**City Link Trucking  
Site Development Plan  
Letter of Intent**

**September 13, 2023**

**PCD File PPR2339**

DP-1

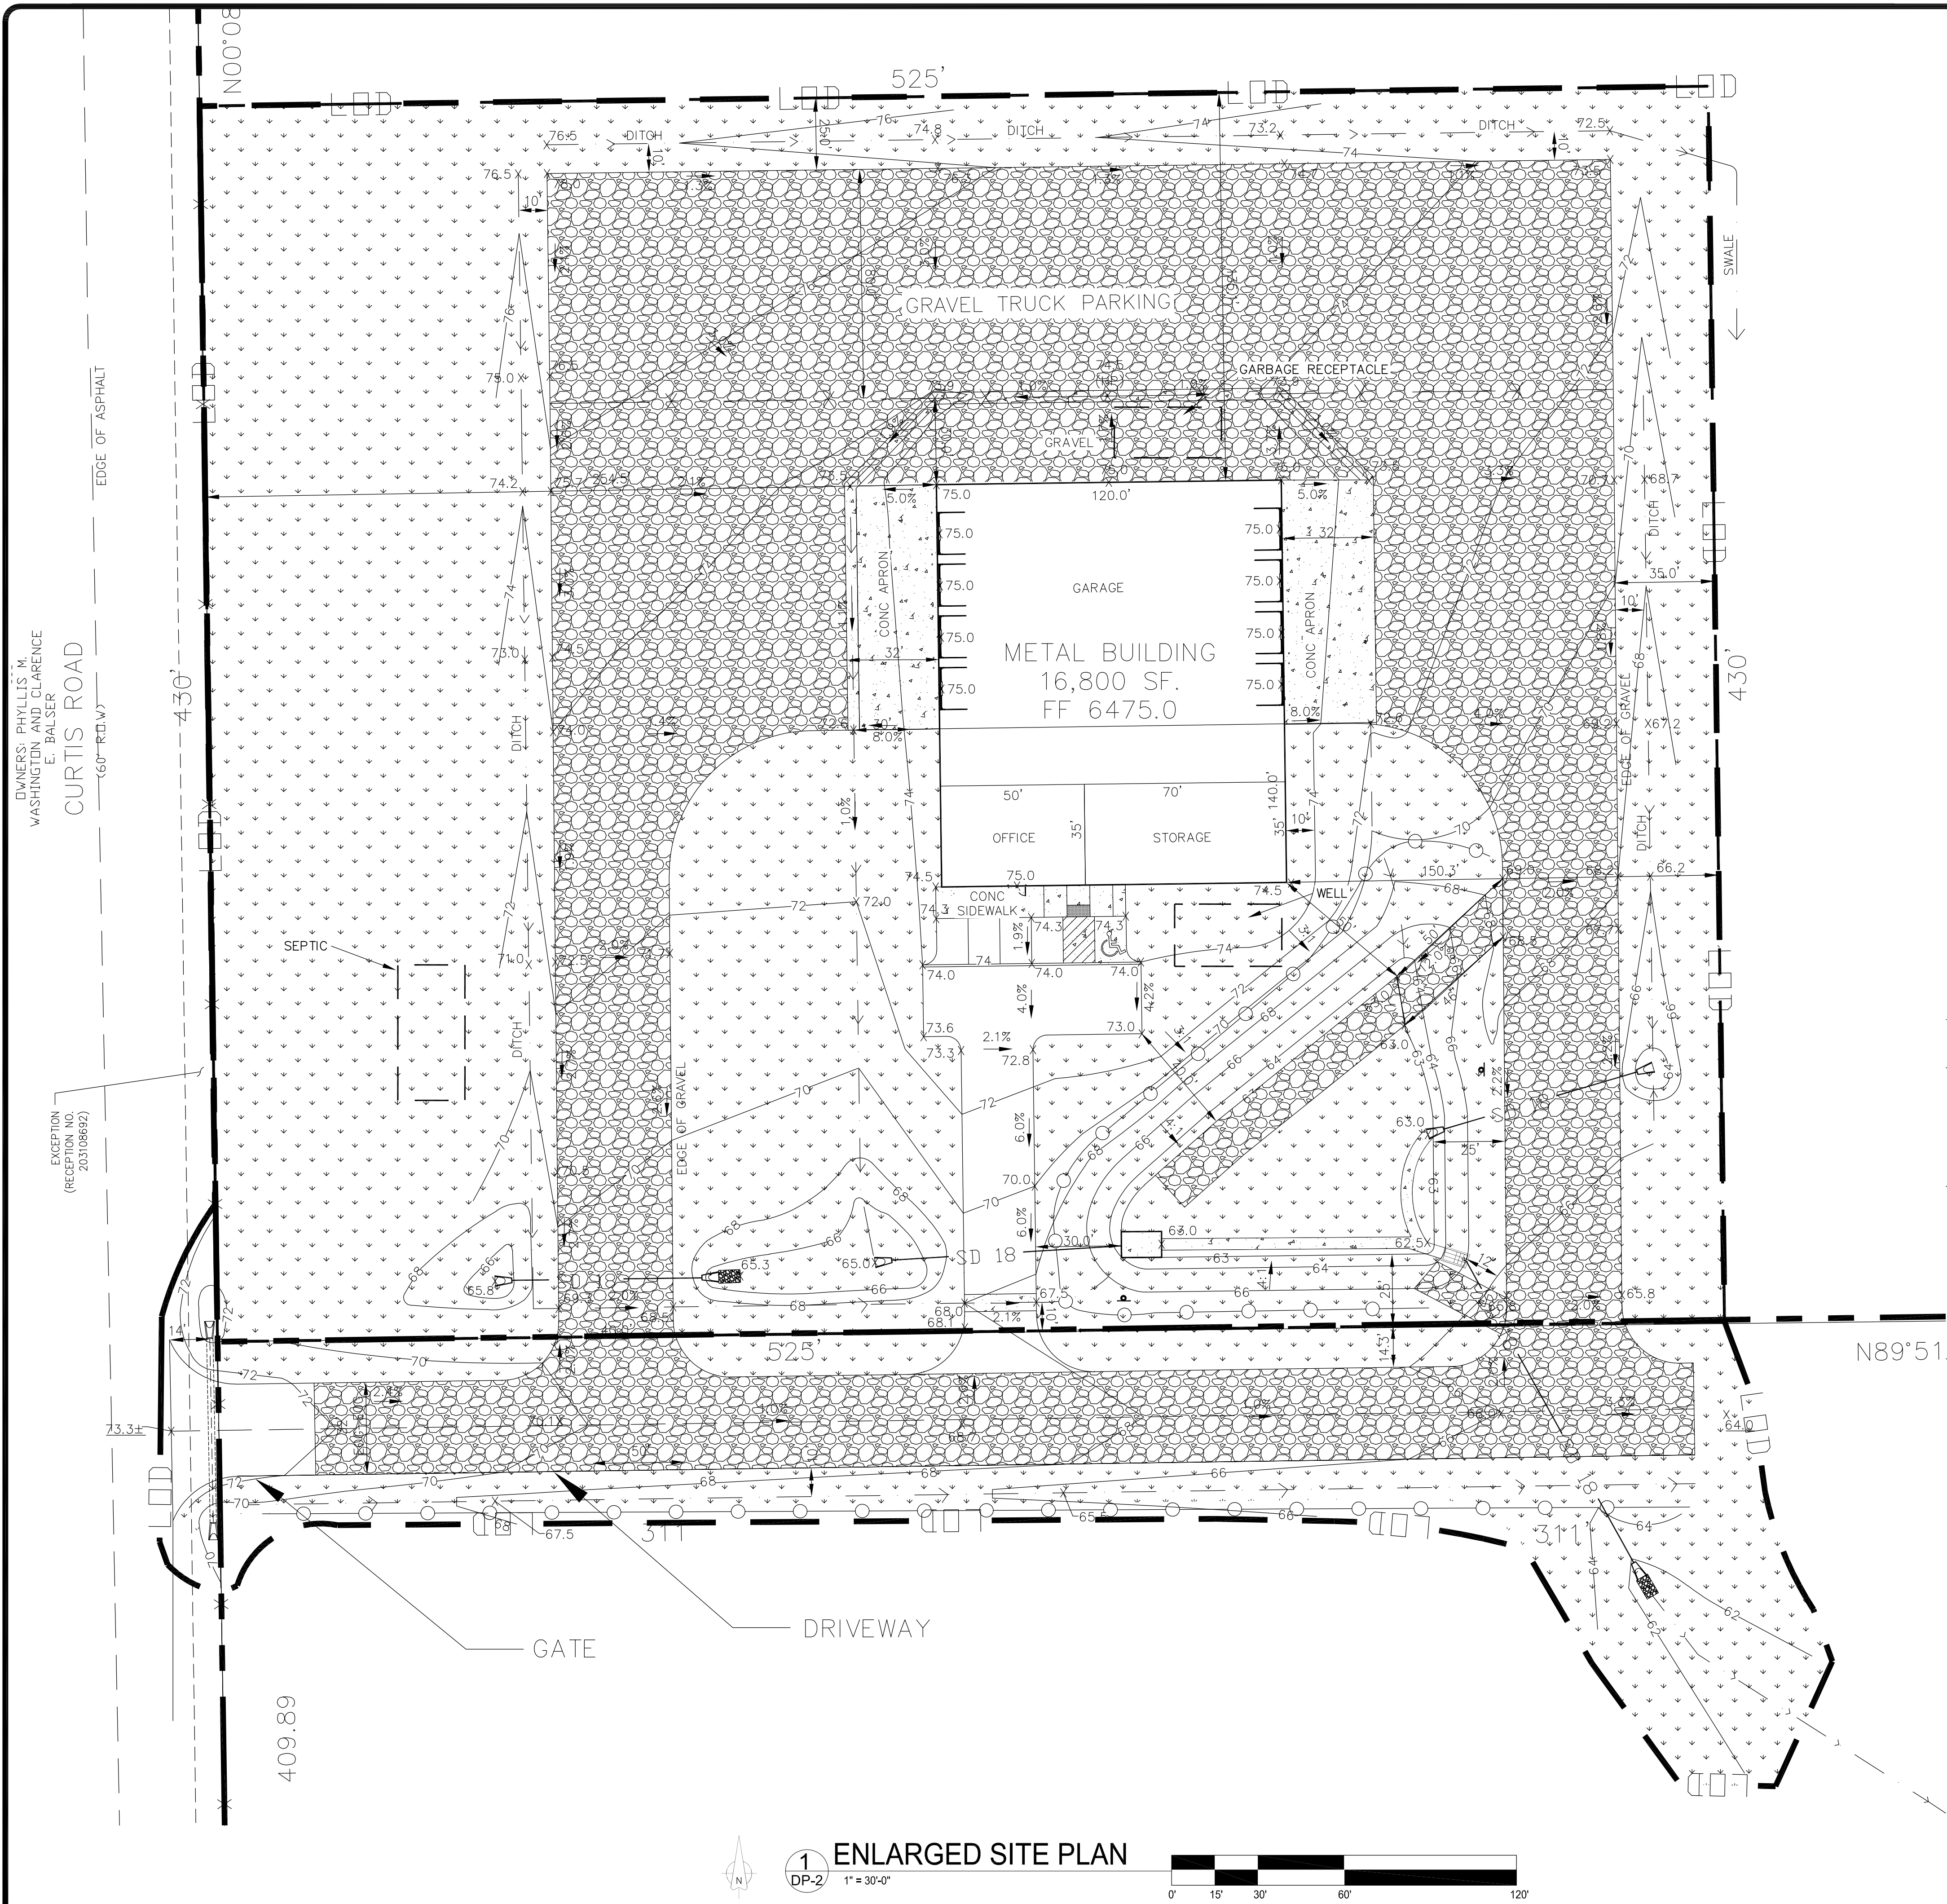
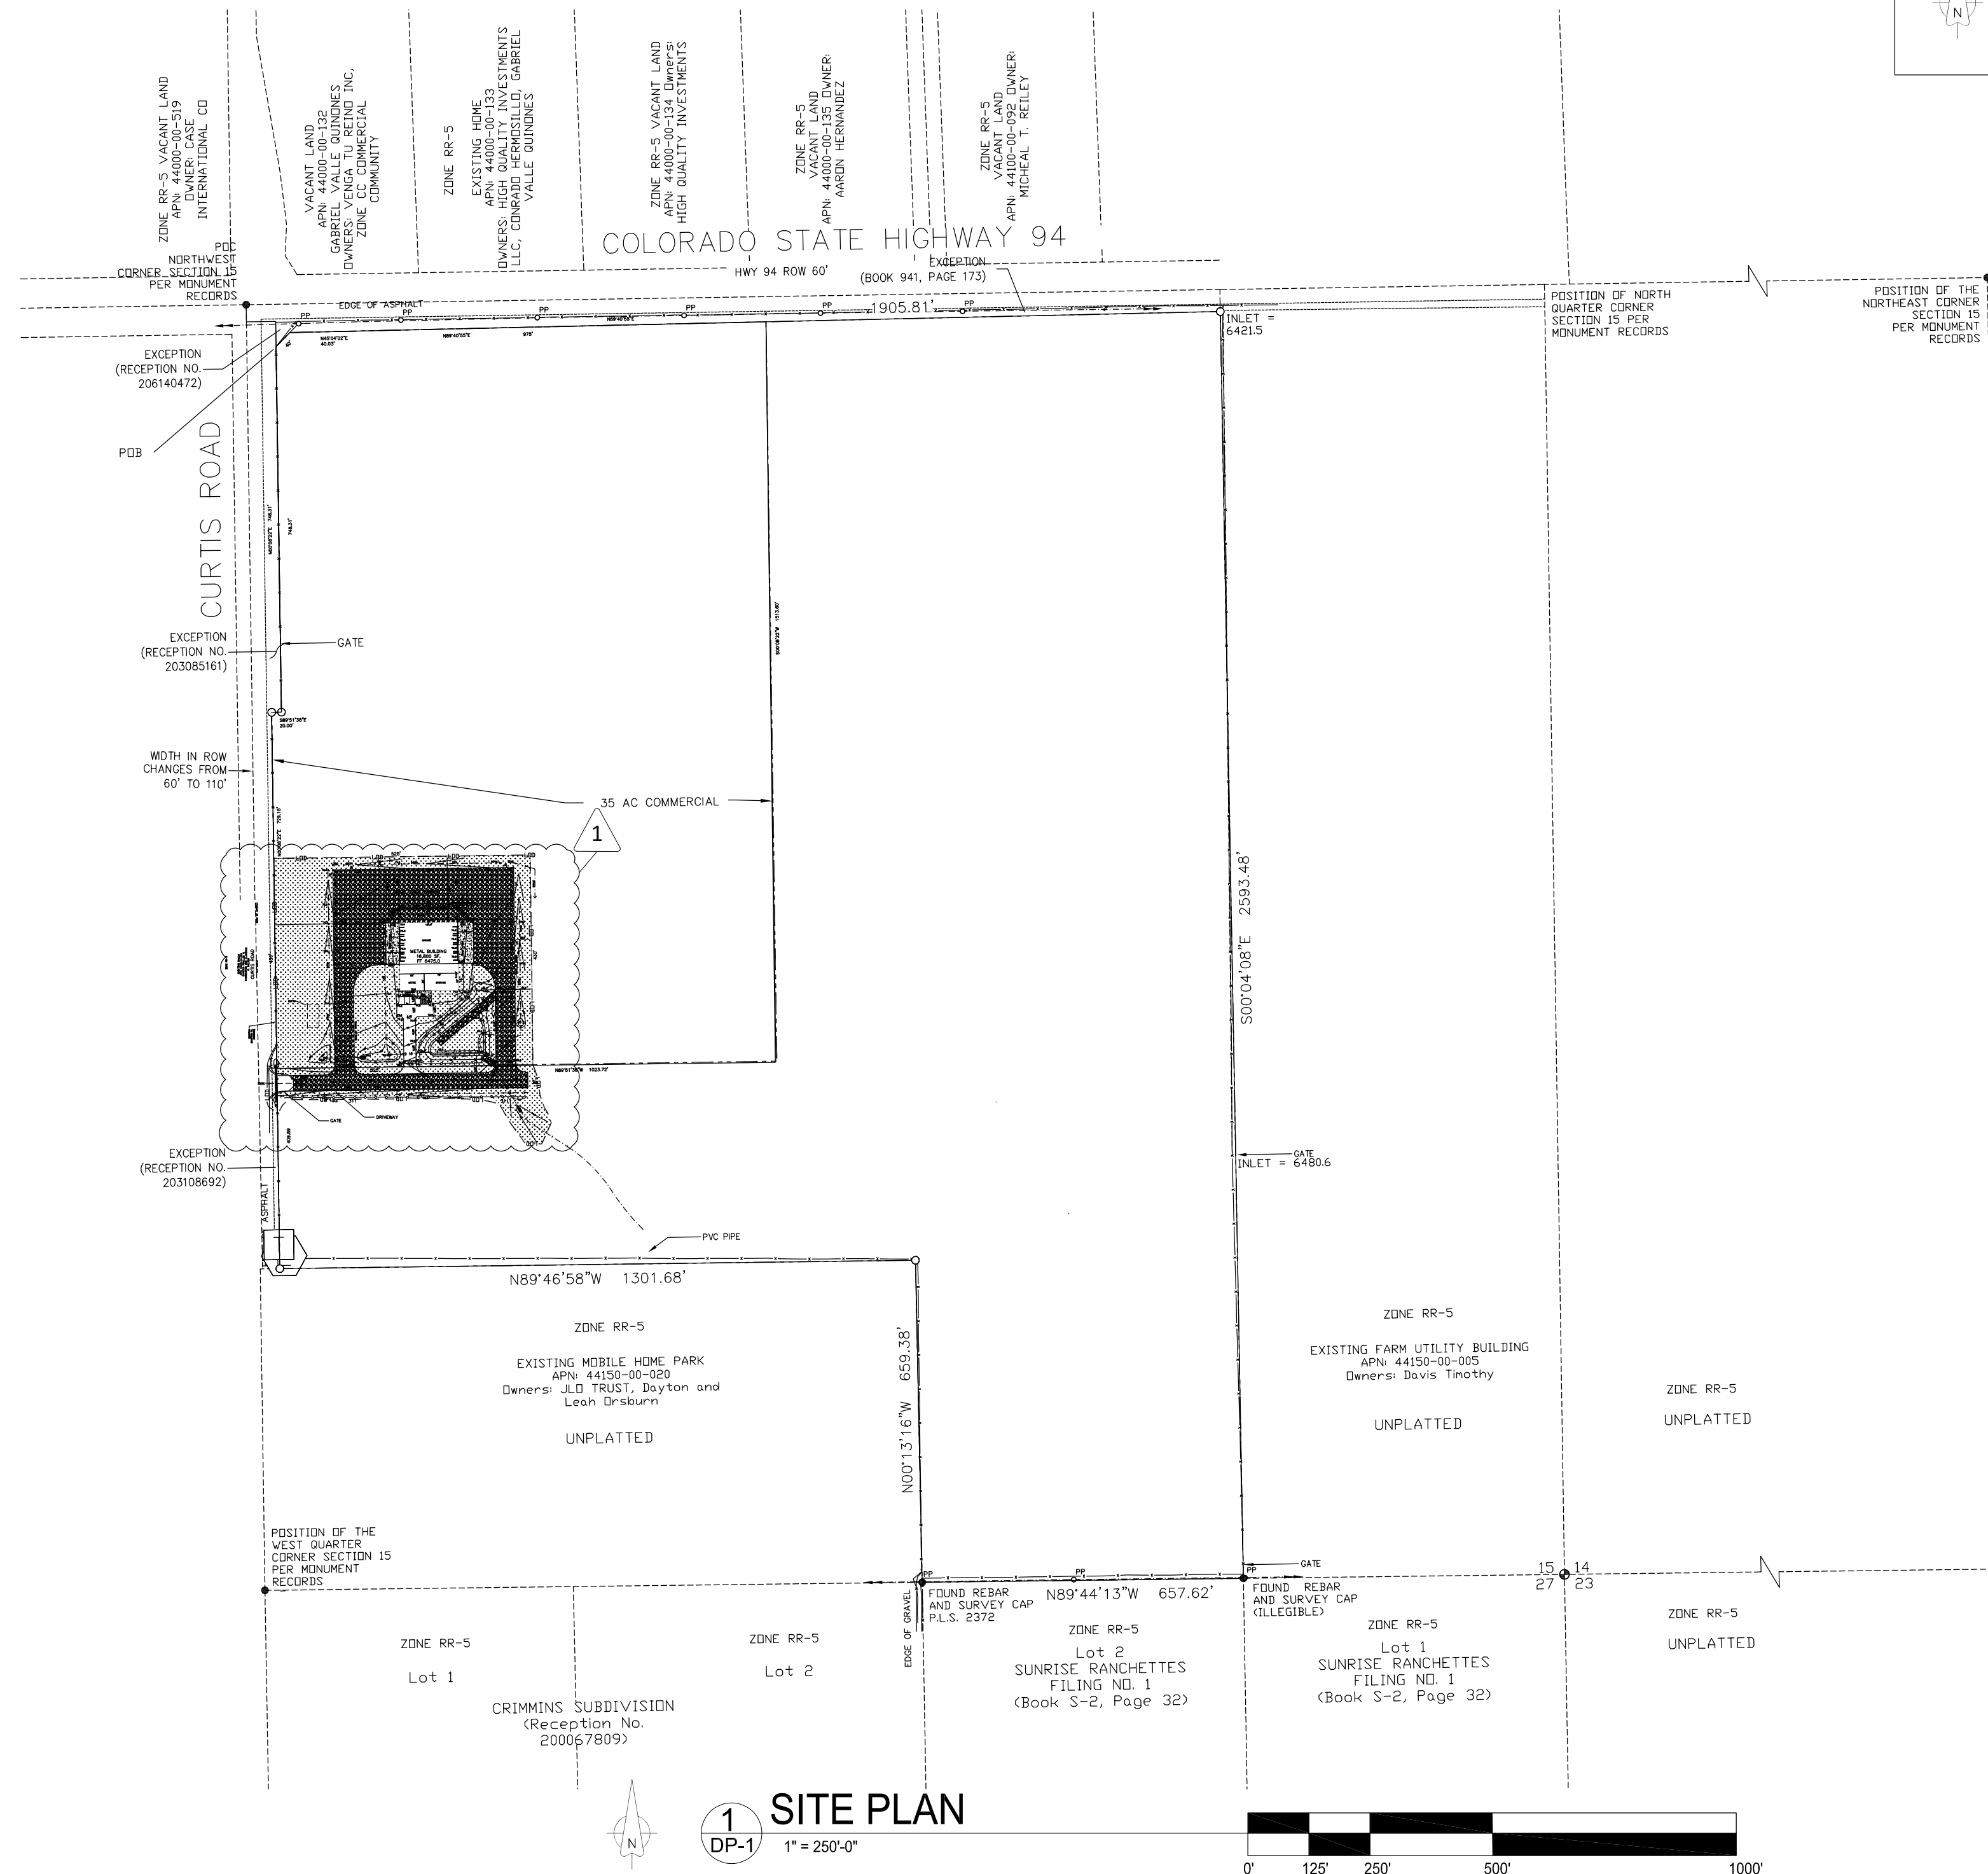
Please clarify if a private road or just a driveway is being constructed. the GEC plan and CDs call out a private road. Please update docs as necessary

Please clarify if site will be open to the public

A driveway access permit will be required.
